DESIGN RESPONSE

20009DA

104-116 REGENT STREET
REDFERN

09 JUN, 22

4 SD-JUNE 12PM
Floor Plan 1: 1500

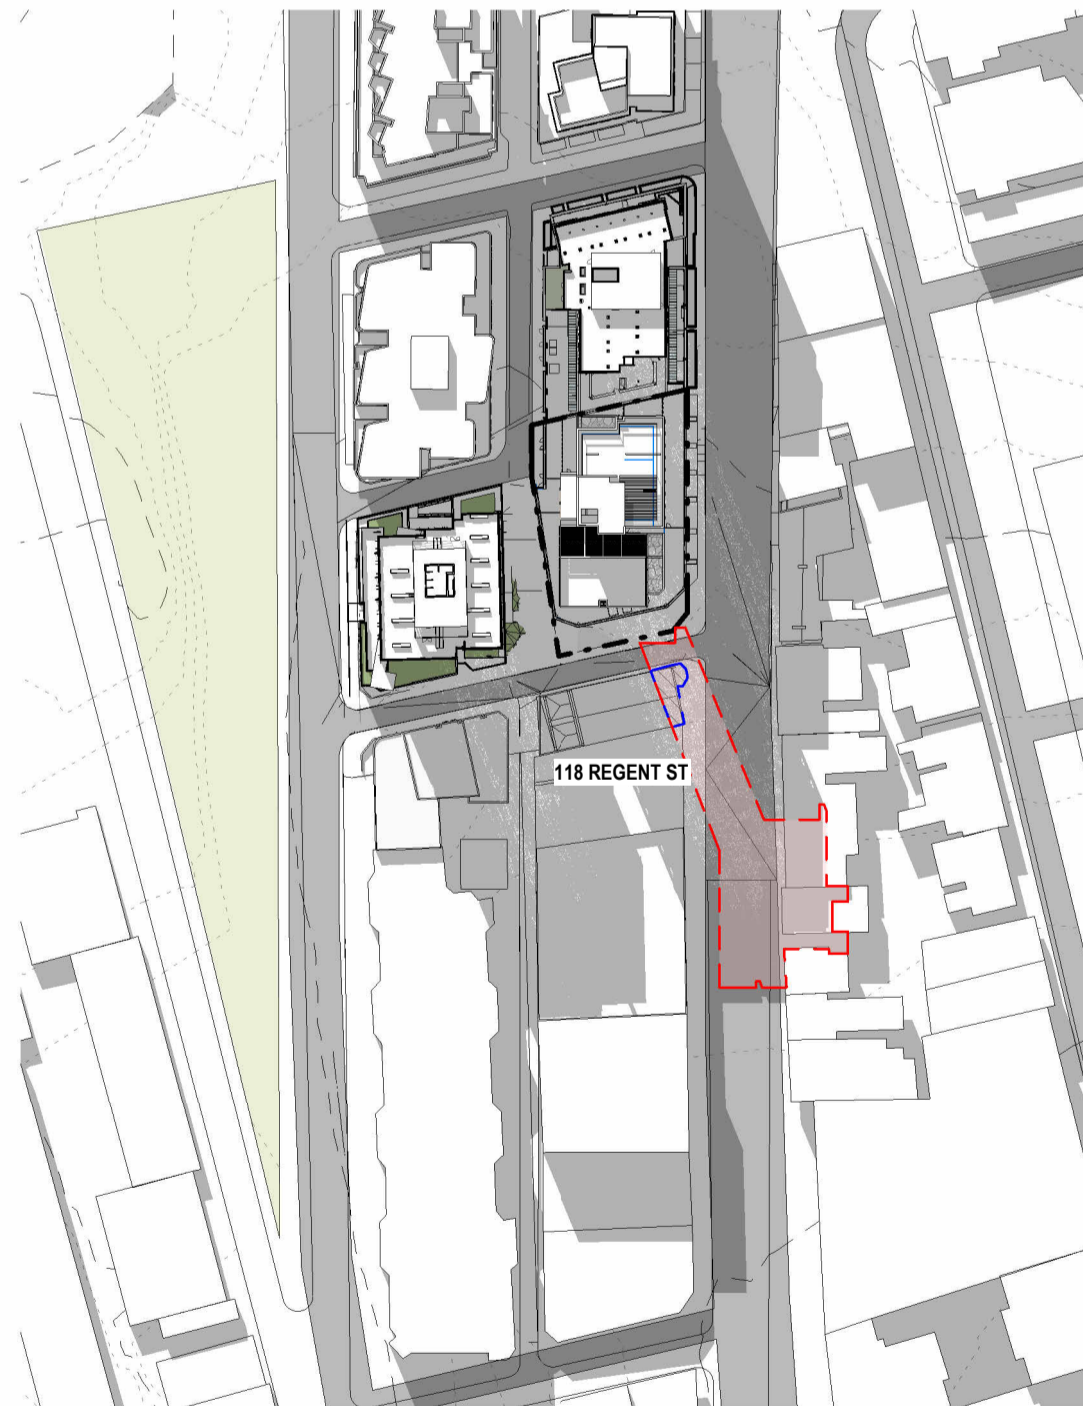
The overshadowing analysis confirms that the proposal would cast a large shadow over properties to the southwest, south and southeast in mid-winter. The analysis does not consider the specifics of any overshadowing on individual properties nor does it capture the full extent of the overshadowing impacts with cropped shadow plans omitting the full shadow extent.

The impact must be quantified, in terms of both the measurable criteria in the RCUDP controls, and any impacts justified of particular concern is the impact to 1 Margaret Street and the playing field at National Centre of Indigenous Excellence at 160-202 George Street.

Additional information, which quantifies resulting solar access, the overshadowing impact, and adequate justification is required for these sites in half hourly views from the sun.

Additional information of half hourly views provided with extended view to capture the south east shadowing. Refer architectural drawings DA 6.02 and DA 6.03 (refer appendix on pages 22 & 23). The proposed built form has been designed to avoid unacceptable shadow impacts to surrounding developments and public domain.

The shadow analysis of proposed development on 1 Margaret Street and 160-202 George Street offers the following assessment :

- Additional overshadowing from amended proposal has minimal impact on 1 Margaret Street , overshadows only small corner area on the south eastern corner outlined in blue (refer to figure15)
- Additional overshadowing from amended proposal overshadows a portion of the playing field at National Centre of Indigenous Excellence only between 2.30 -3.00pm

5 Signage location
Floor Plan 1:200

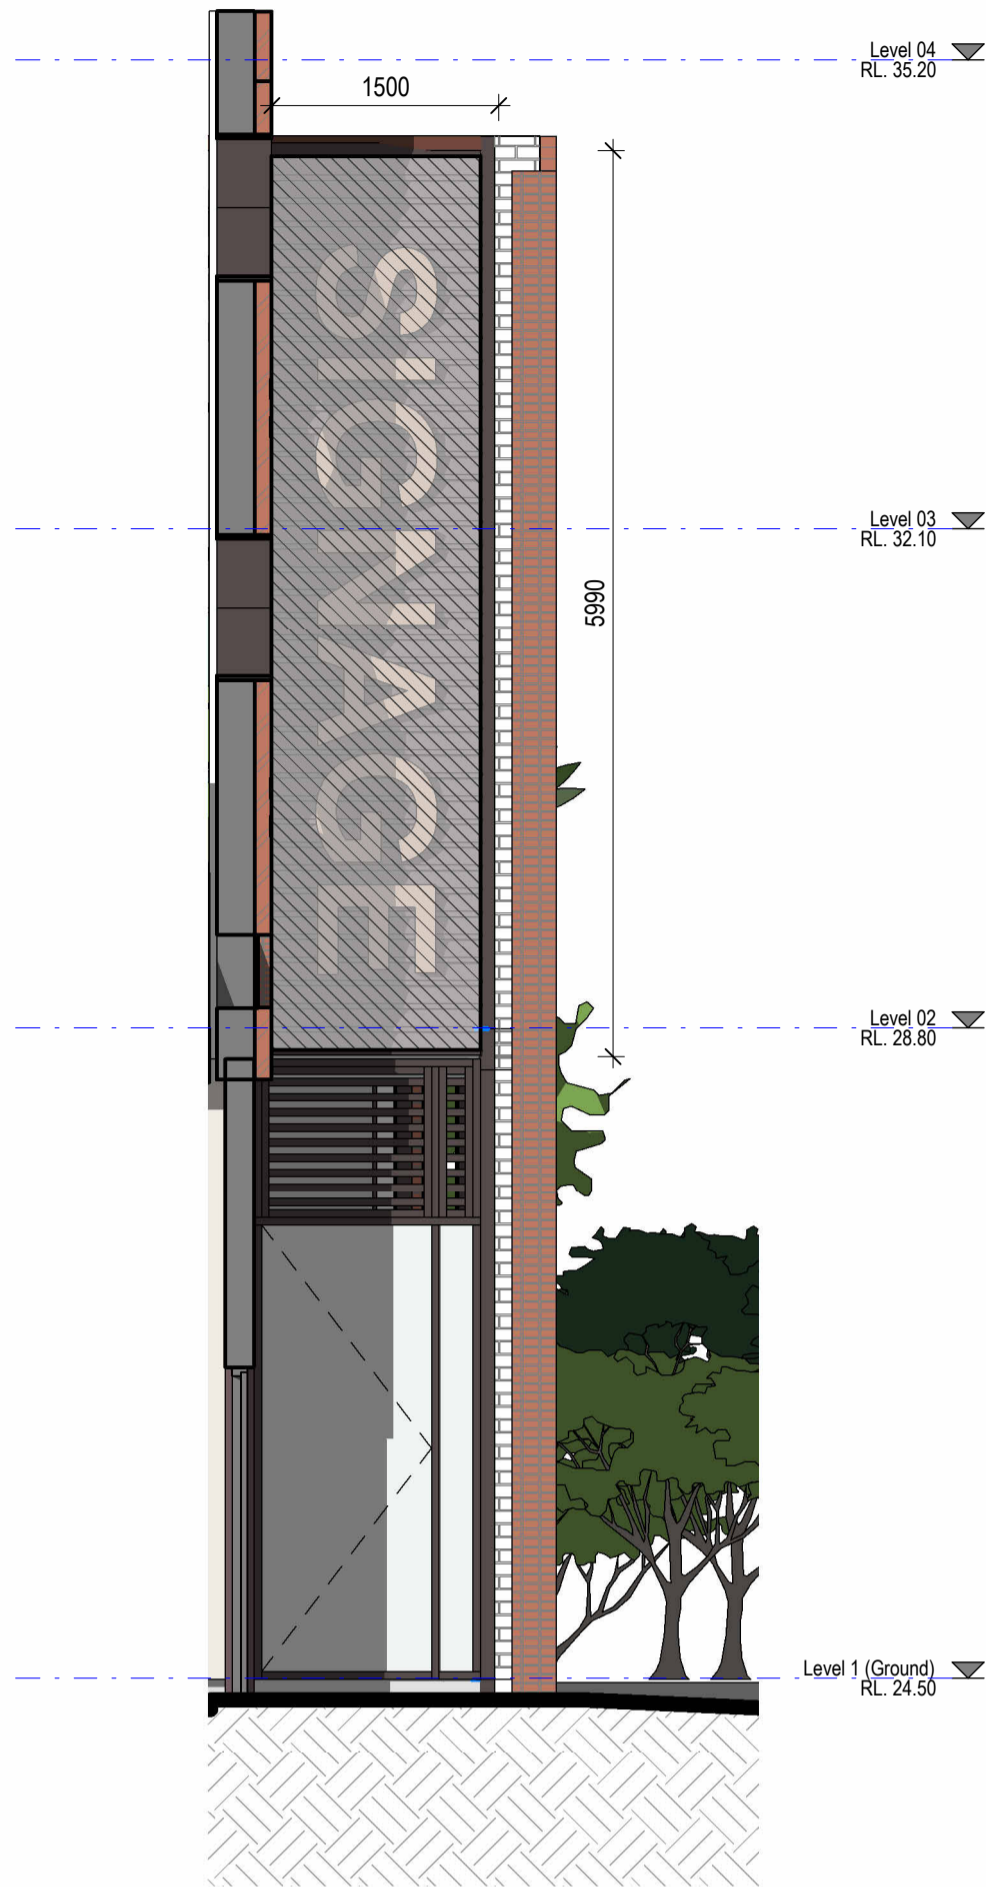
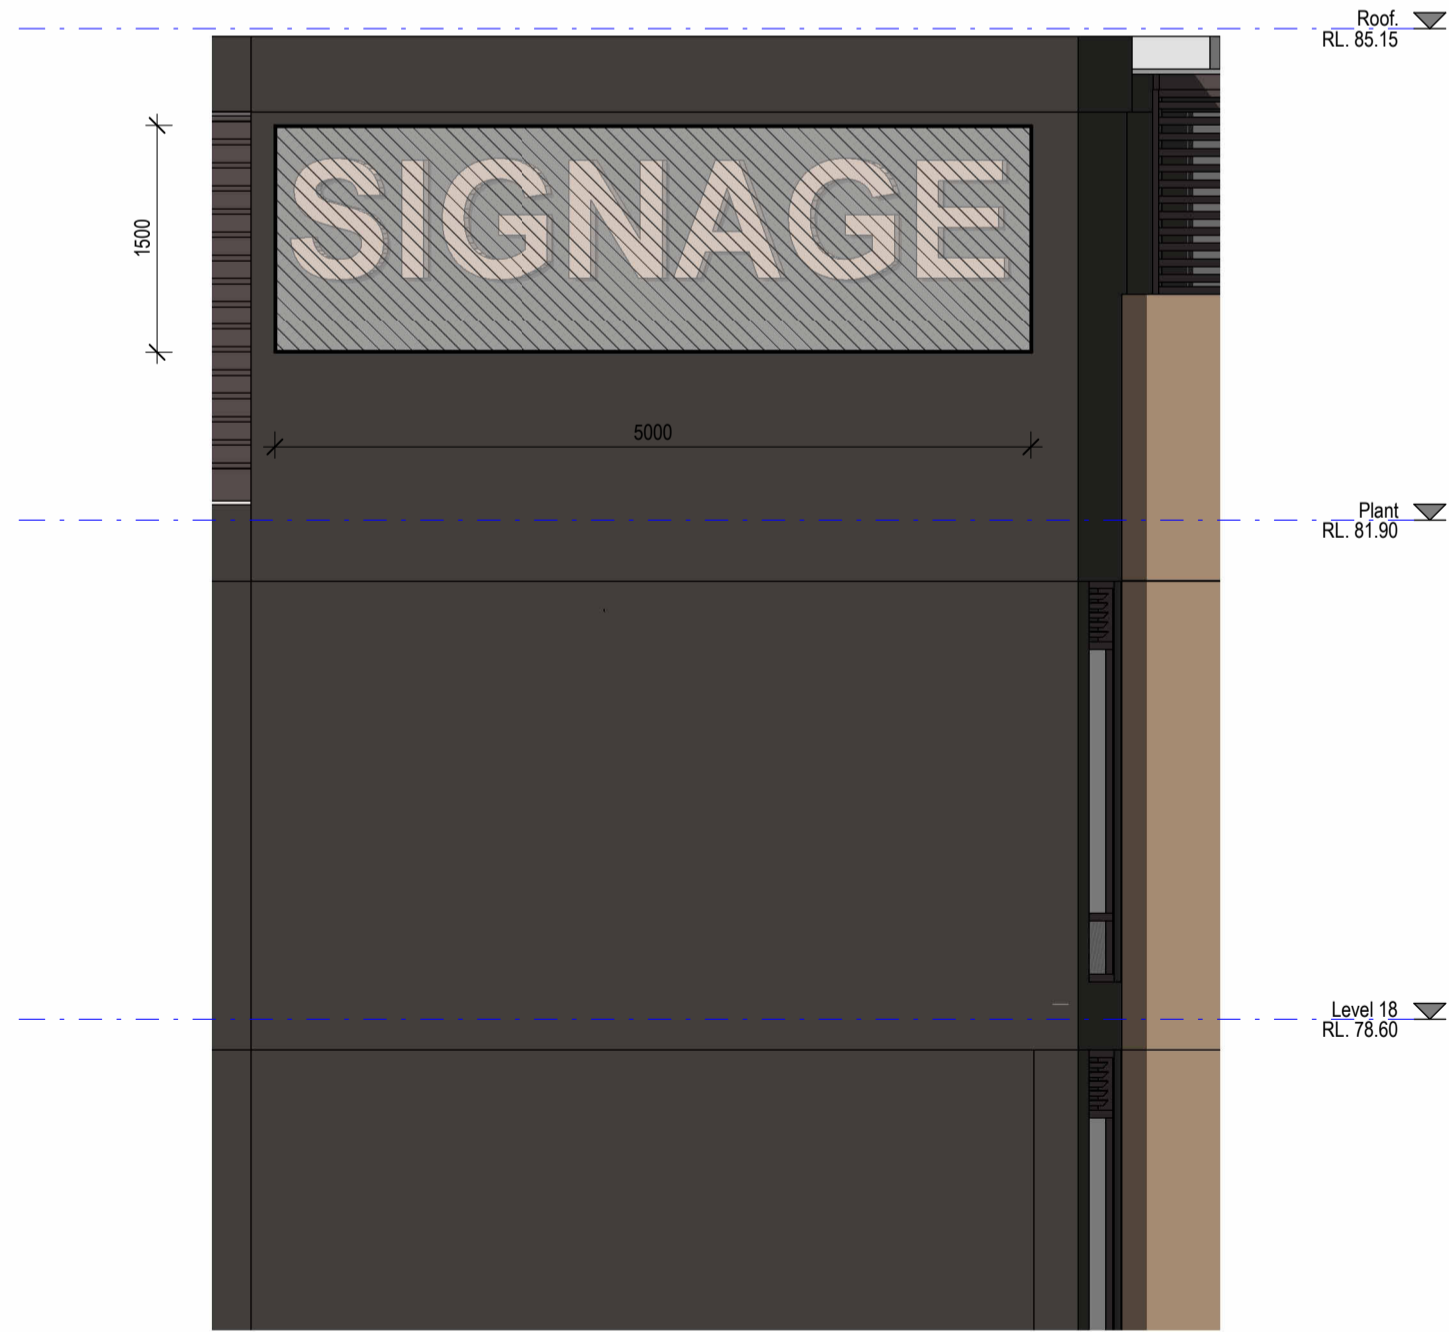
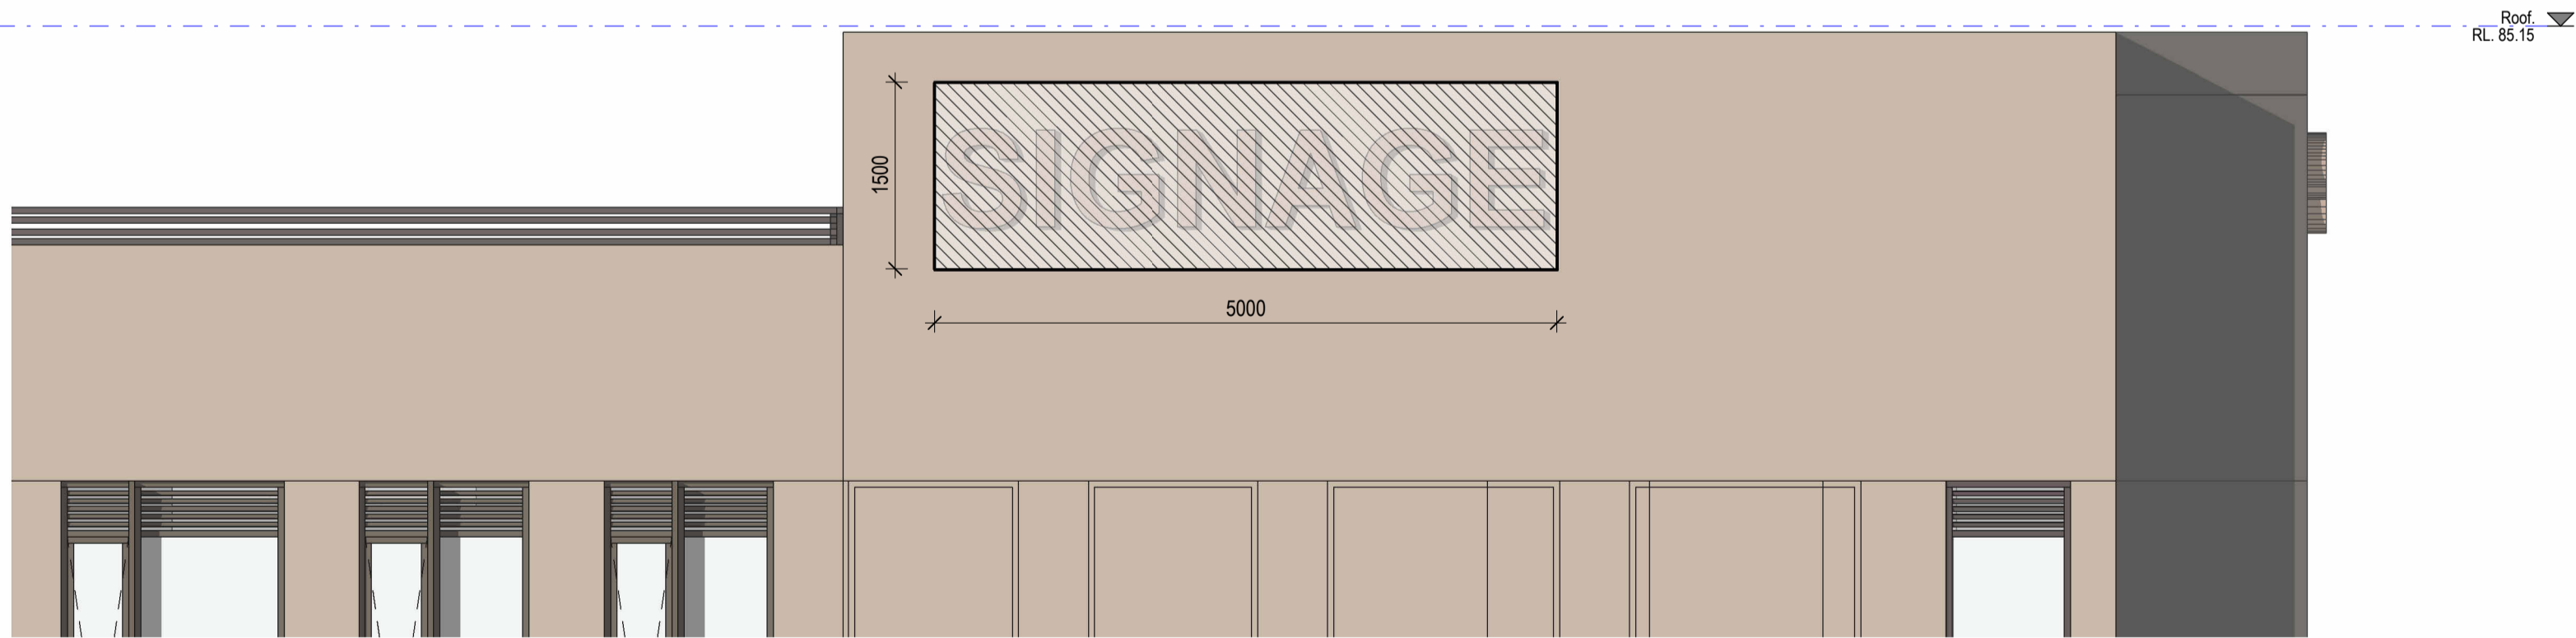
The RCUDP requires a signage strategy be prepared for the entire development. The Regent Street podium signage is not supported as it is not in accordance with RCUDP 3.4.2 signage requirements. An under-awning sign would be supported which assists identifying the entry to pedestrians. Two top of building signs are proposed which contribute to visual clutter. The William Lane signage is recommended to be removed as this will be partially blocked by the Gibbons Street towers. The colour of the proposed signage is not supported as it highly contrasts and is not sympathetic with the proposed colour palette

Refer architectural drawing DA 7.03 for updated Signage zones. The details of the signage is subject to separate DA.

The revised proposal of signage zones includes :

- Under awning signage on Regent street included replacing the previous podium signage.
- New Podium signage on William Lane over the new bike Entry to assist in identifying the entry from William Lane.
- Top of building signage on Margaret Street.
- Top of building signage on William Lane repositioned with visibility considered (refer to figure 23)
